From: Mau, Russell E (DOH) <Russell.Mau@DOH.WA.GOV>
Sent: Friday, March 21, 2025 8:41 AM
To: Ellie Myers
Cc: Melissa Schumaier
Subject: RE: SP-25-00005 Hanson - Notice of Application

The Department of Health (DOH) Office of Drinking Water (ODW) has reviewed the application generating the following official comments:

Subject: SP-25-00005 Hanson - Notice of Application

HANSON ROAD SHORT PLAT
 PART OF SECTION 11, T. 17 N., R. 17 E., W.M.
 KITTITAS COUNTY, WASHINGTON

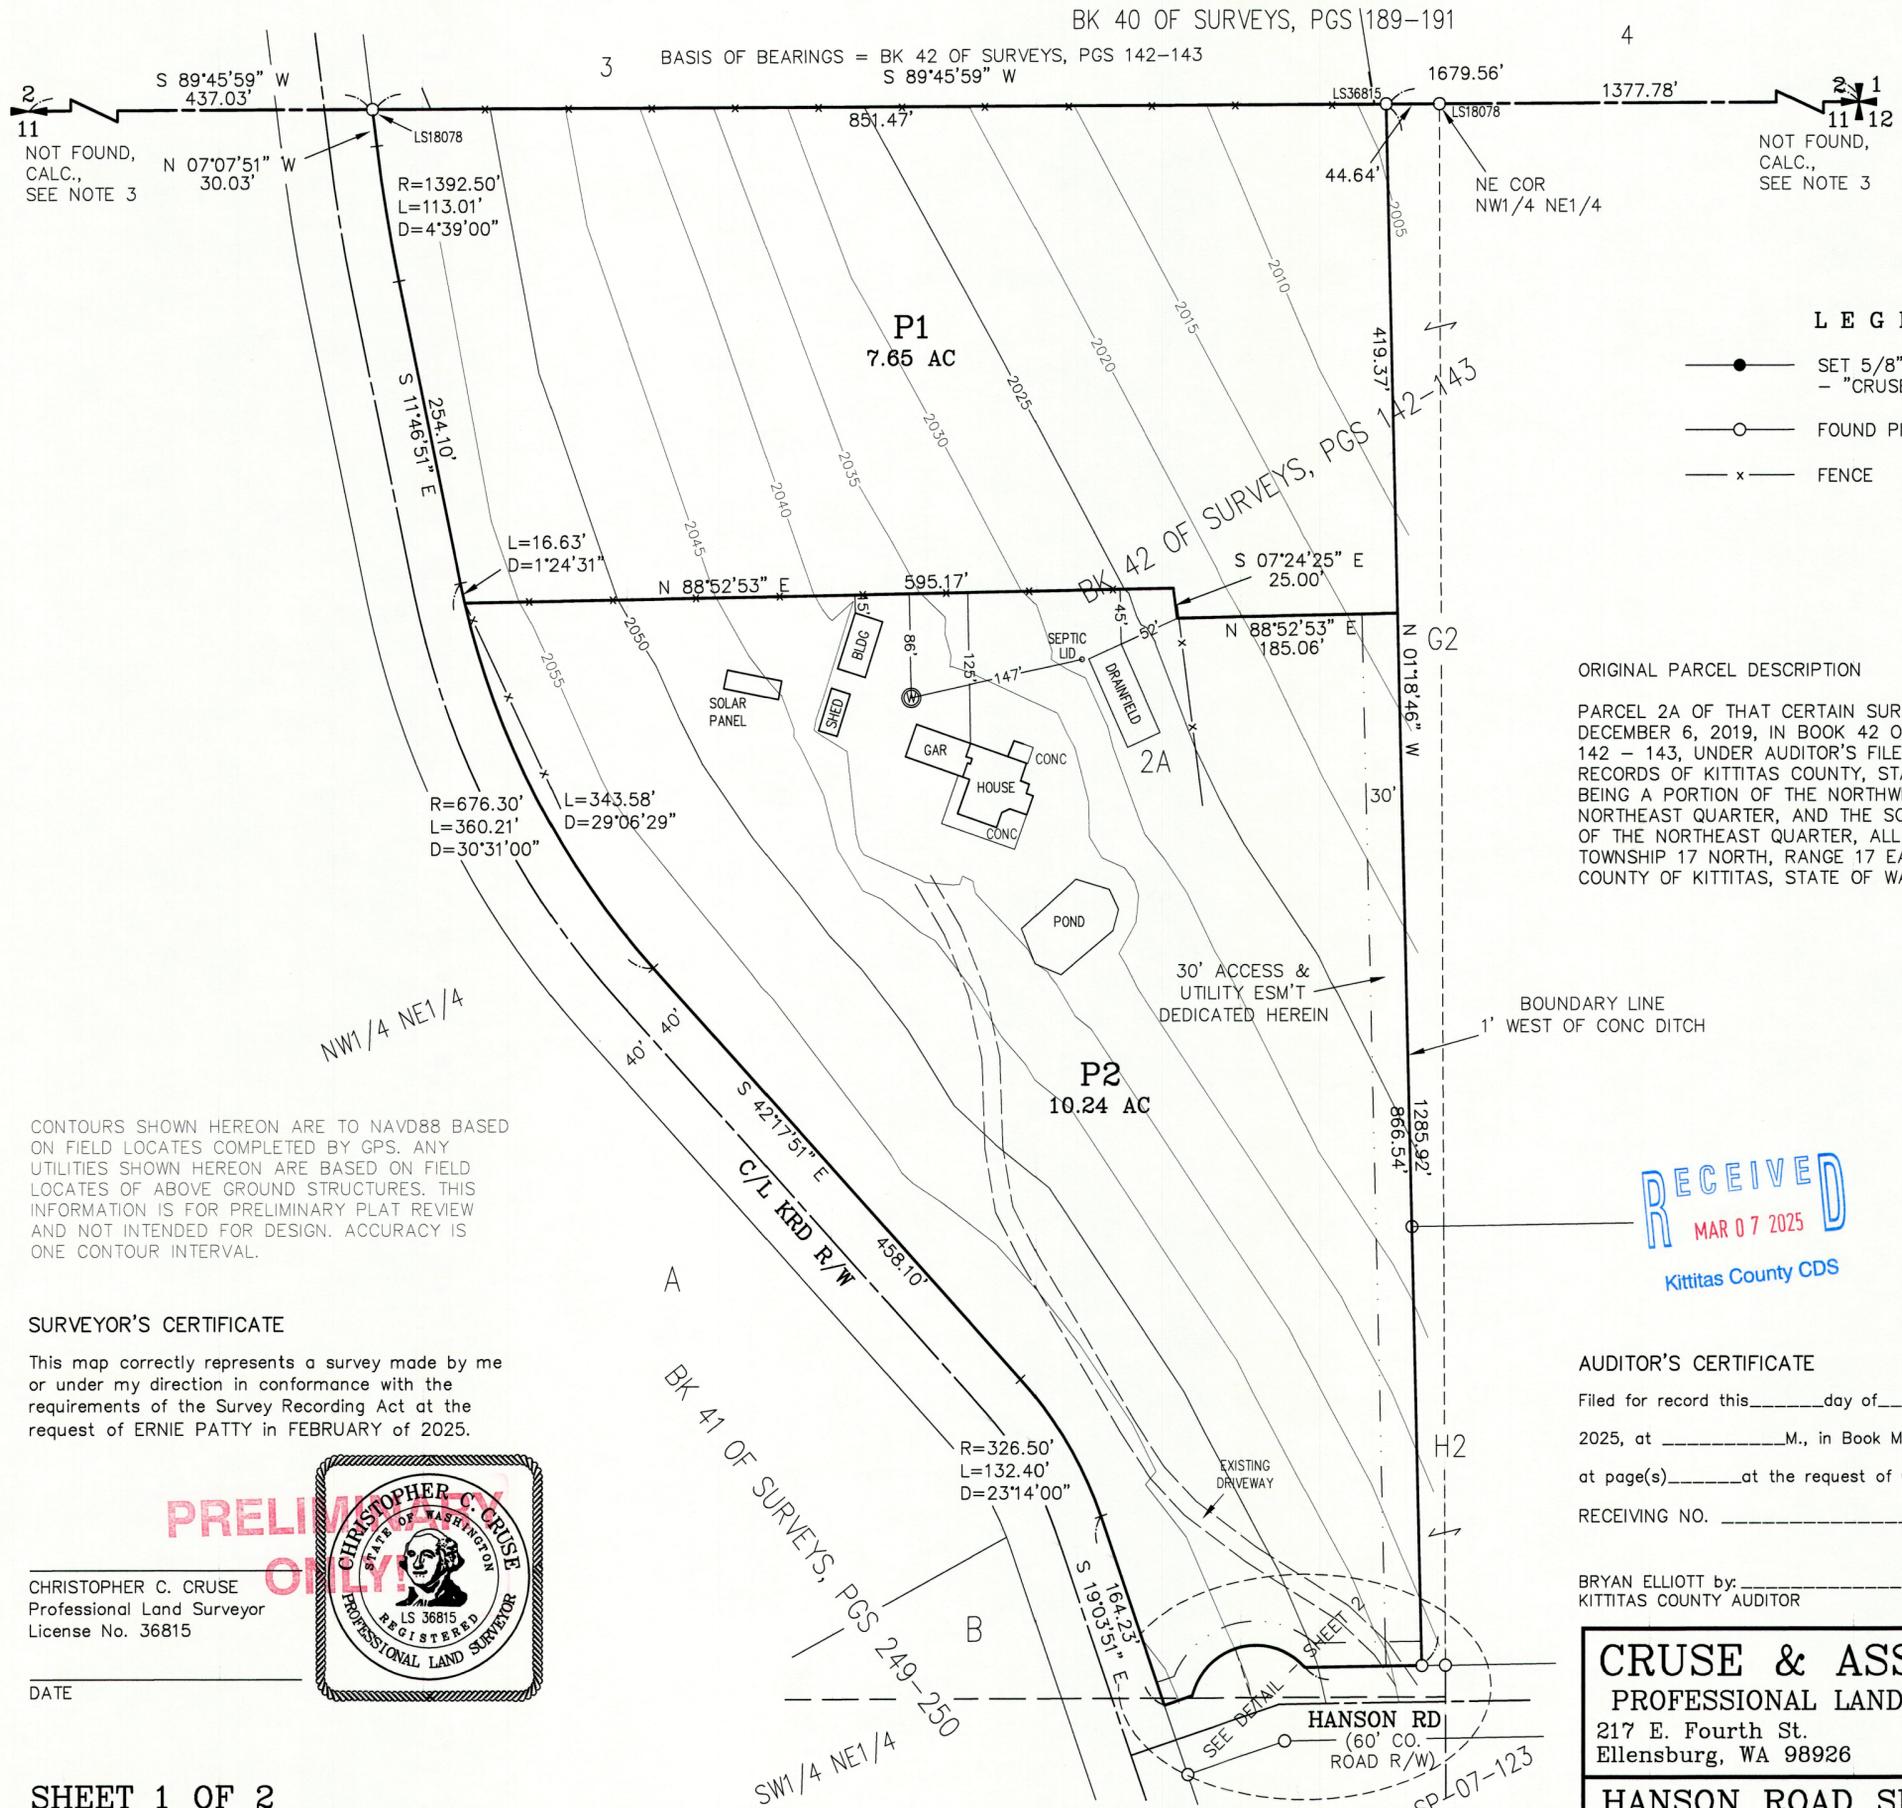
- A shared well – shared by two single-family homes – is a private well and not subject to public drinking water regulations.
- If the applicant were to add a third connection to this common well whether another property or an additional structure or apartment on one of the current properties, then the use of the well would be public requiring public water system review. In this case, the water system would be a “Group B” and under the exclusive administration by Kittitas County Health.
